11th October 2021

Application No: FG/163/21/PL
Site Address: The Chalet Littlehampton Road Ferring BN12 6PG
Description of works: Development comprising of marine workshop & boatyard, martial arts gym (Class E) & storage container compound (Class B8) to replace former glasshouses. This site is a Departure from the Development Plan & is in CIL Zone 3 (Zero Rated) as other development.

Thank you for your internet representation made on 10th October 2021 which has been recorded as an objection with the comments as follows:

SITE PLAN 1:500 @ A3

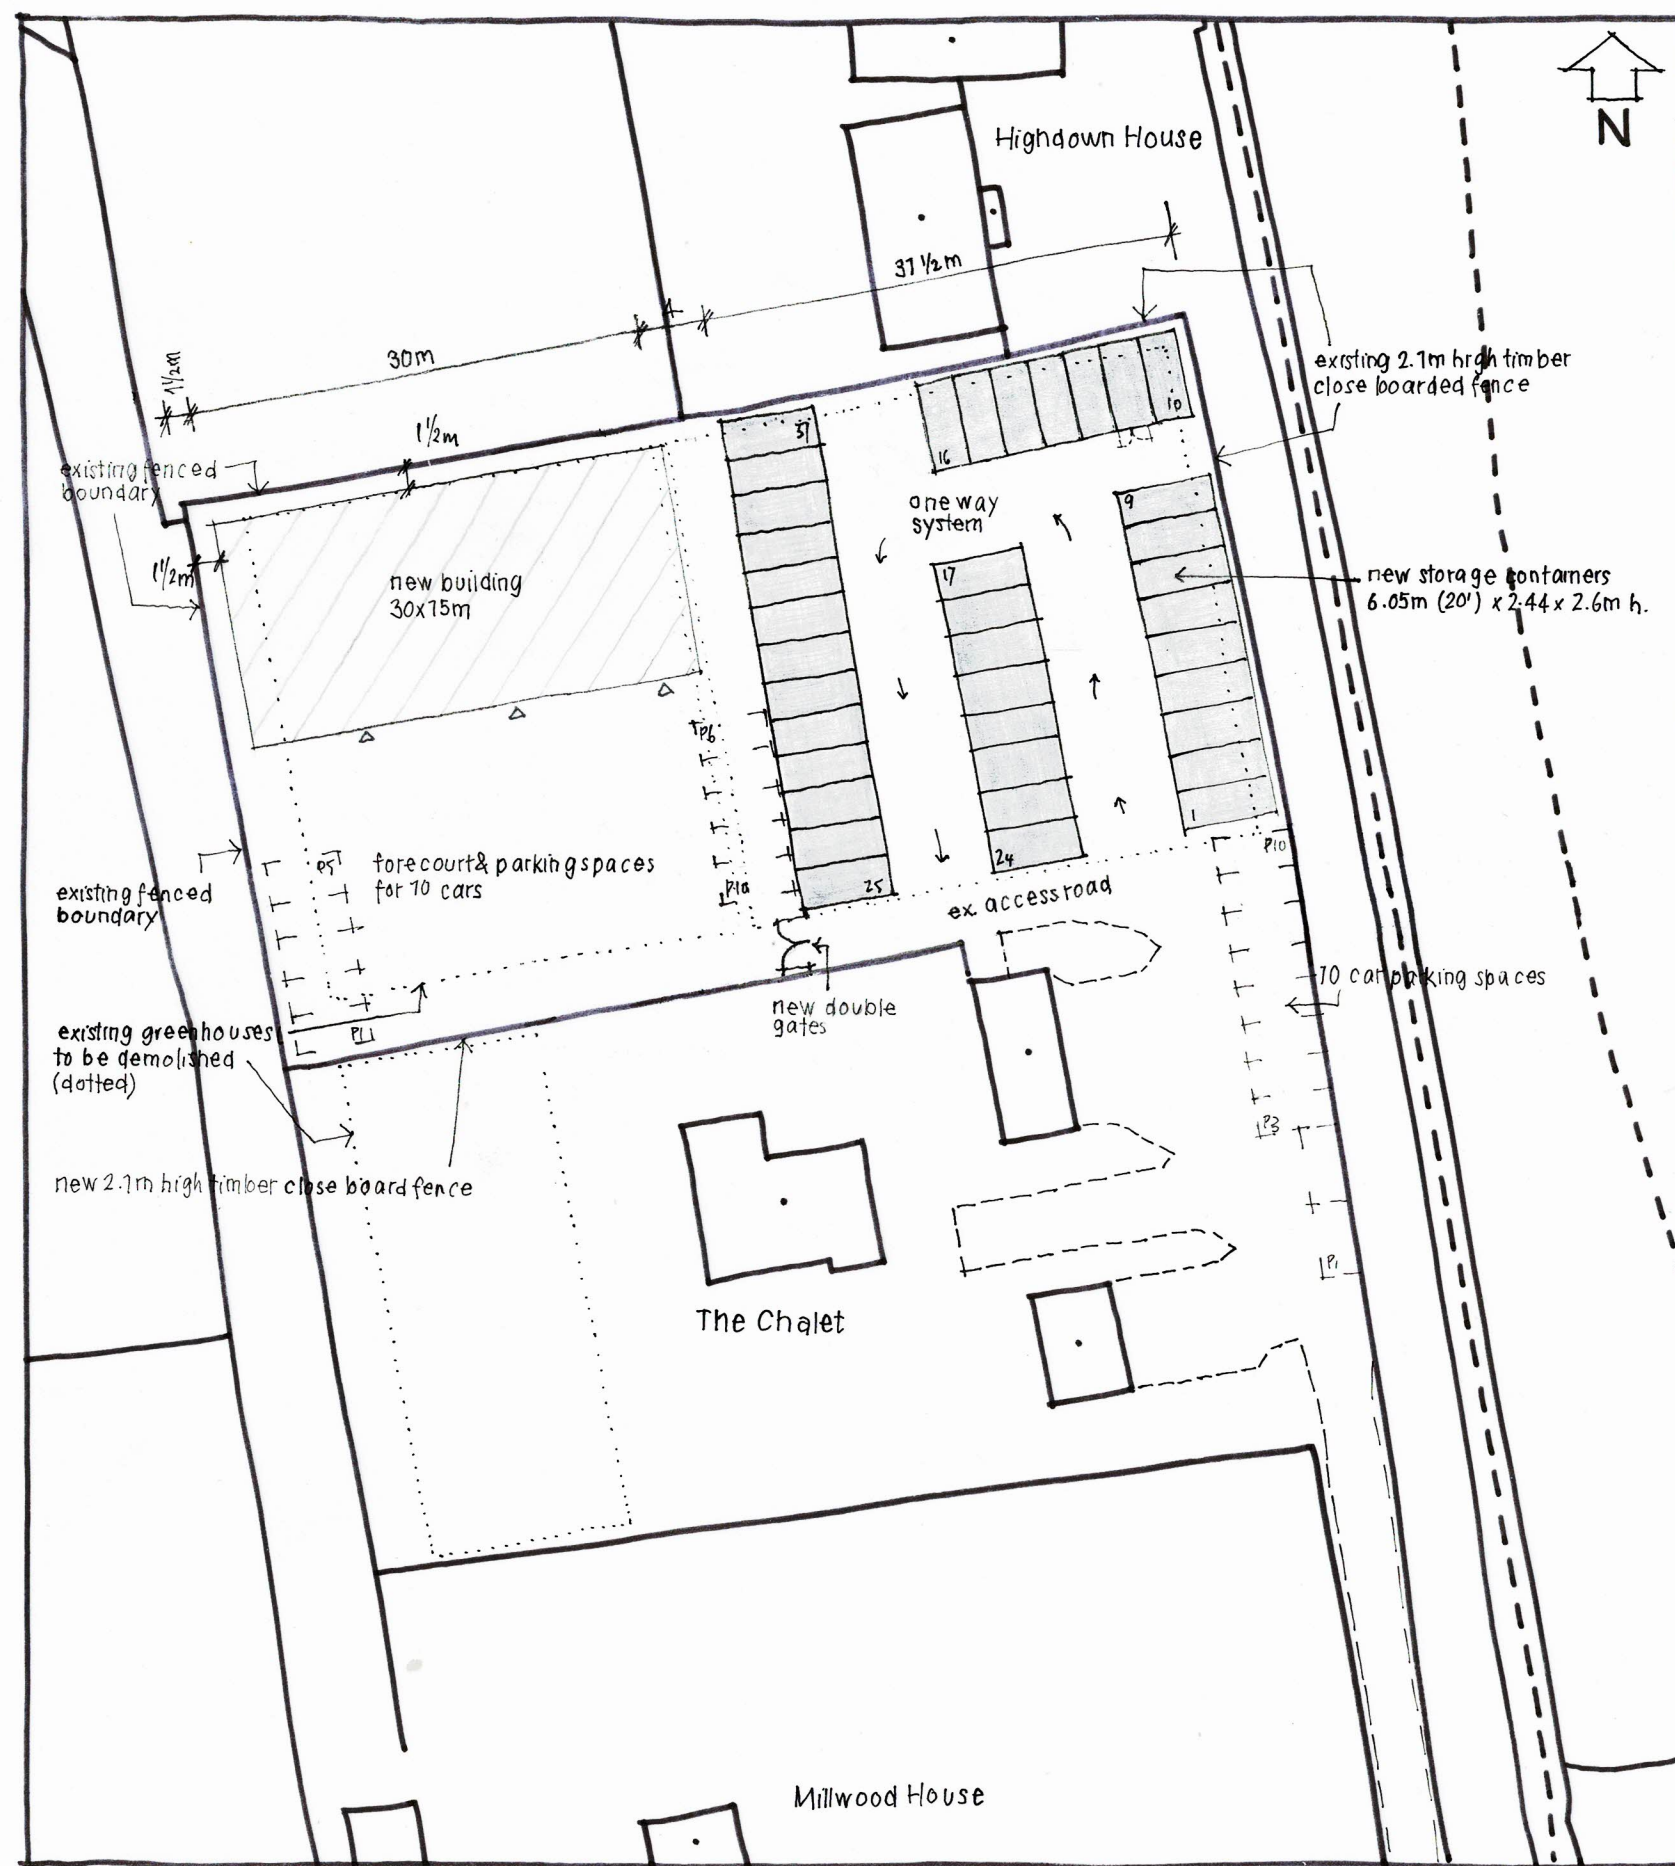
Having seen the proposal, we cannot see how large vehicles will safely enter/exit the said site safely. We also feel that the greenhouses should be retained for growing purposes.
